Condition 3.

Hennock International Ltd

Construction details v2

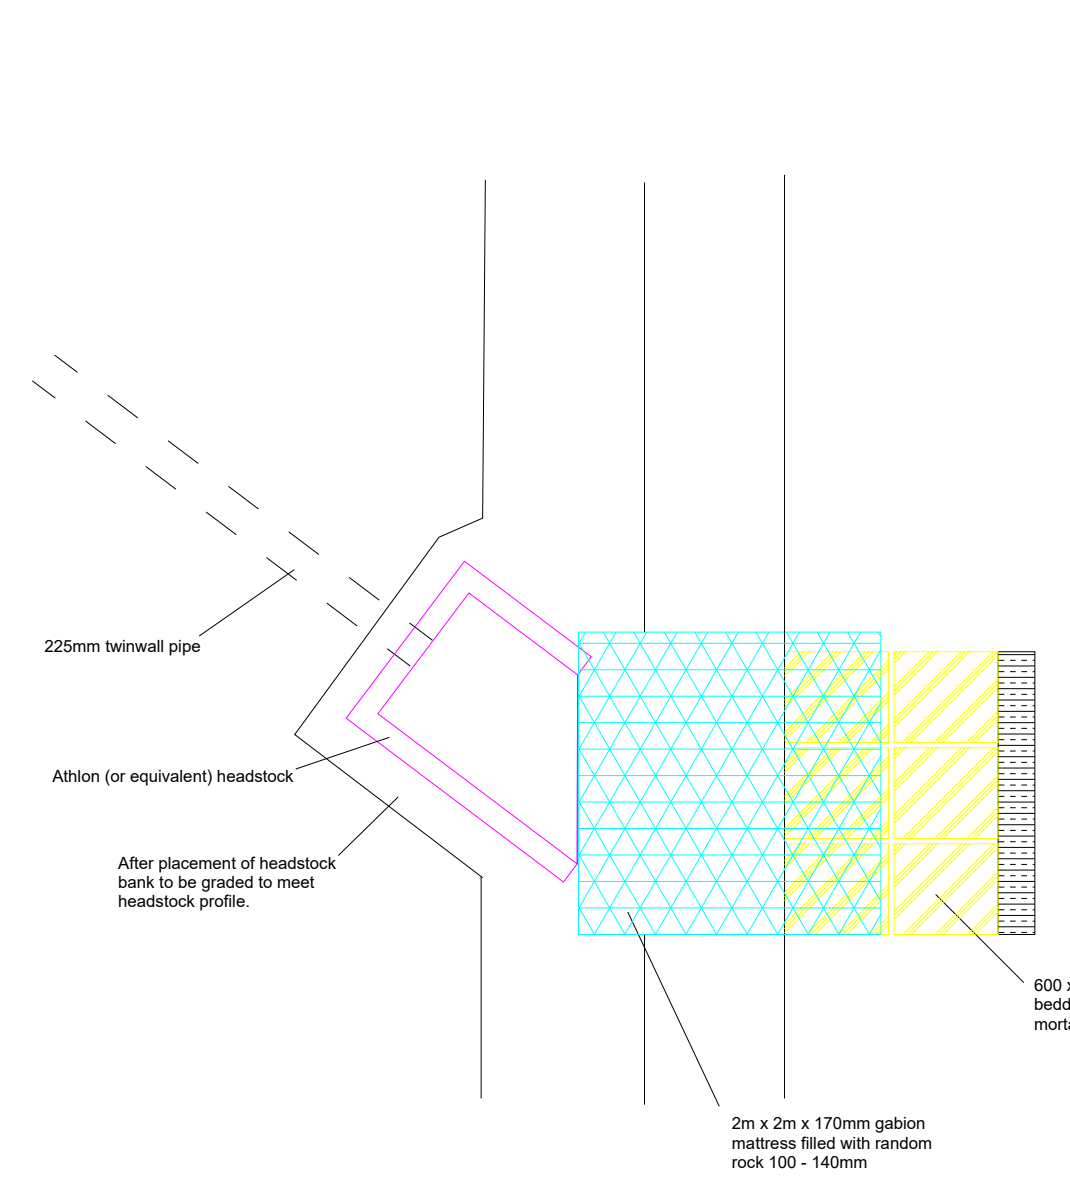
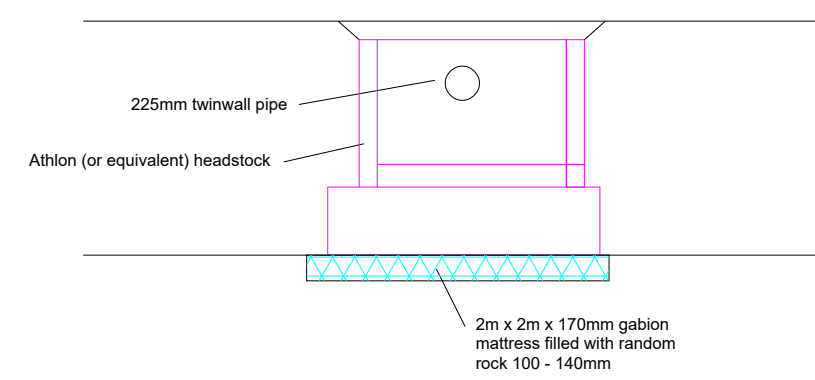
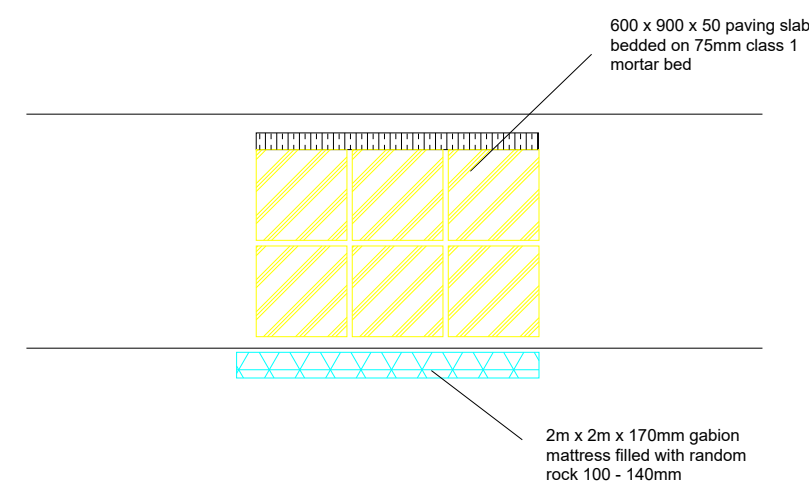
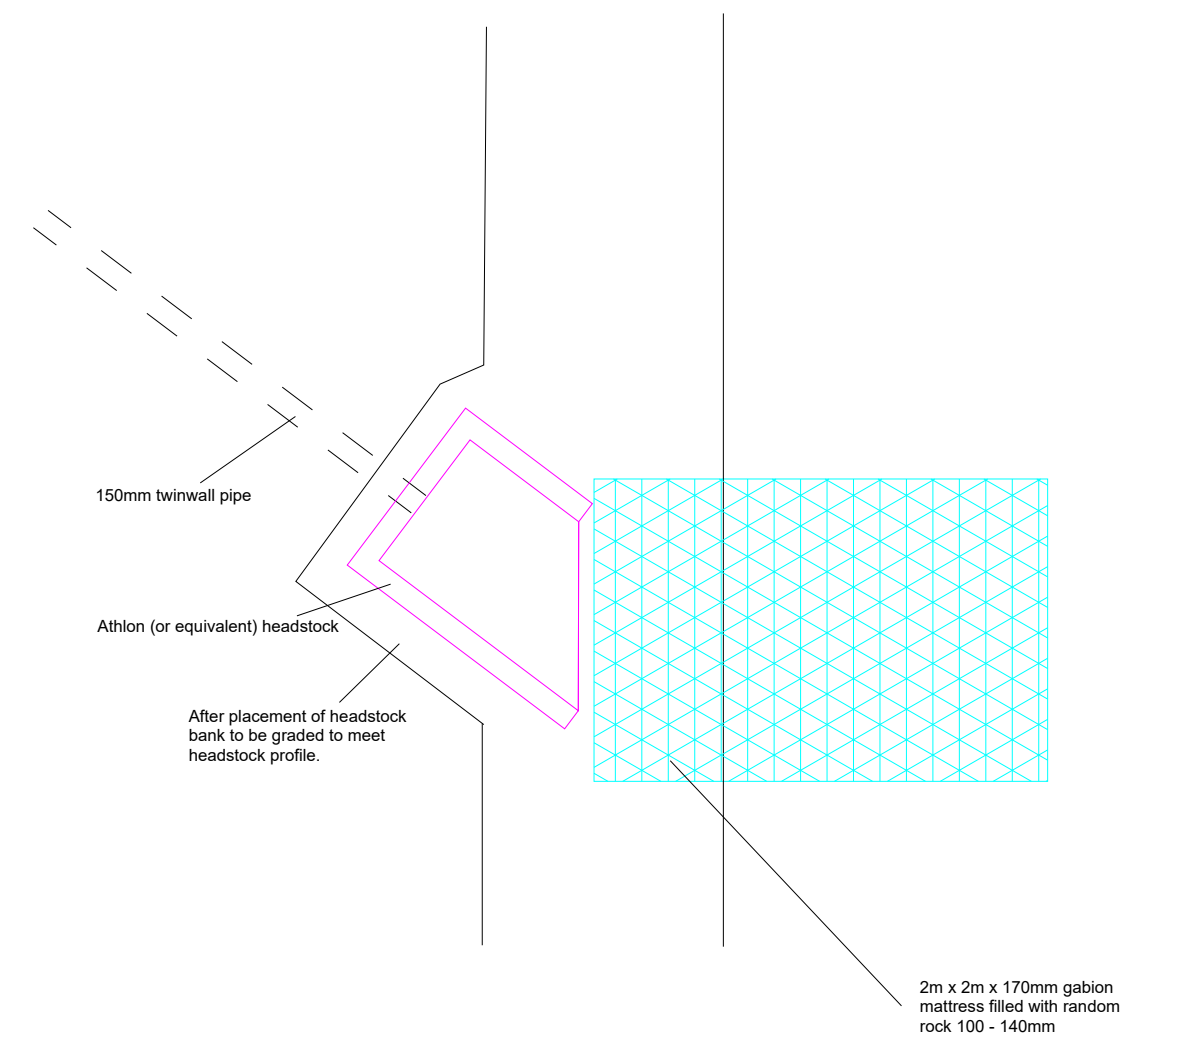
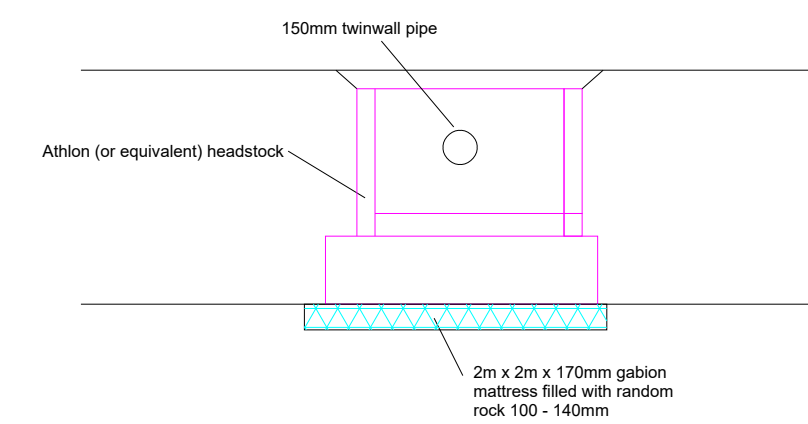
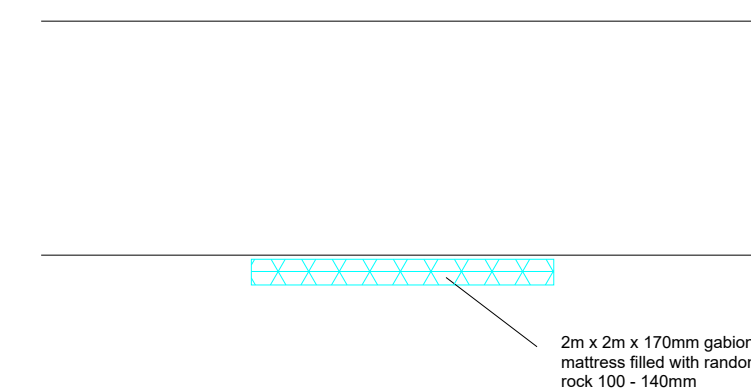
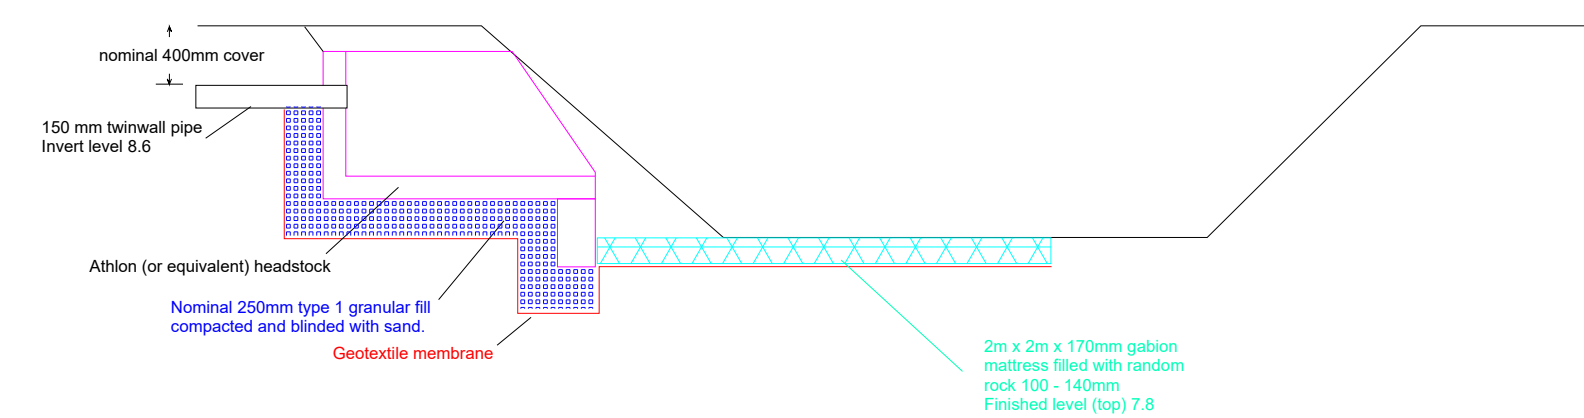
Construction details for the headwall as agreed as part of the Ordinary Discharge Consent are enclosed, see drawings "Outfall North", "Outfall South", "Outfall construction v2" and also "Construction Notes".
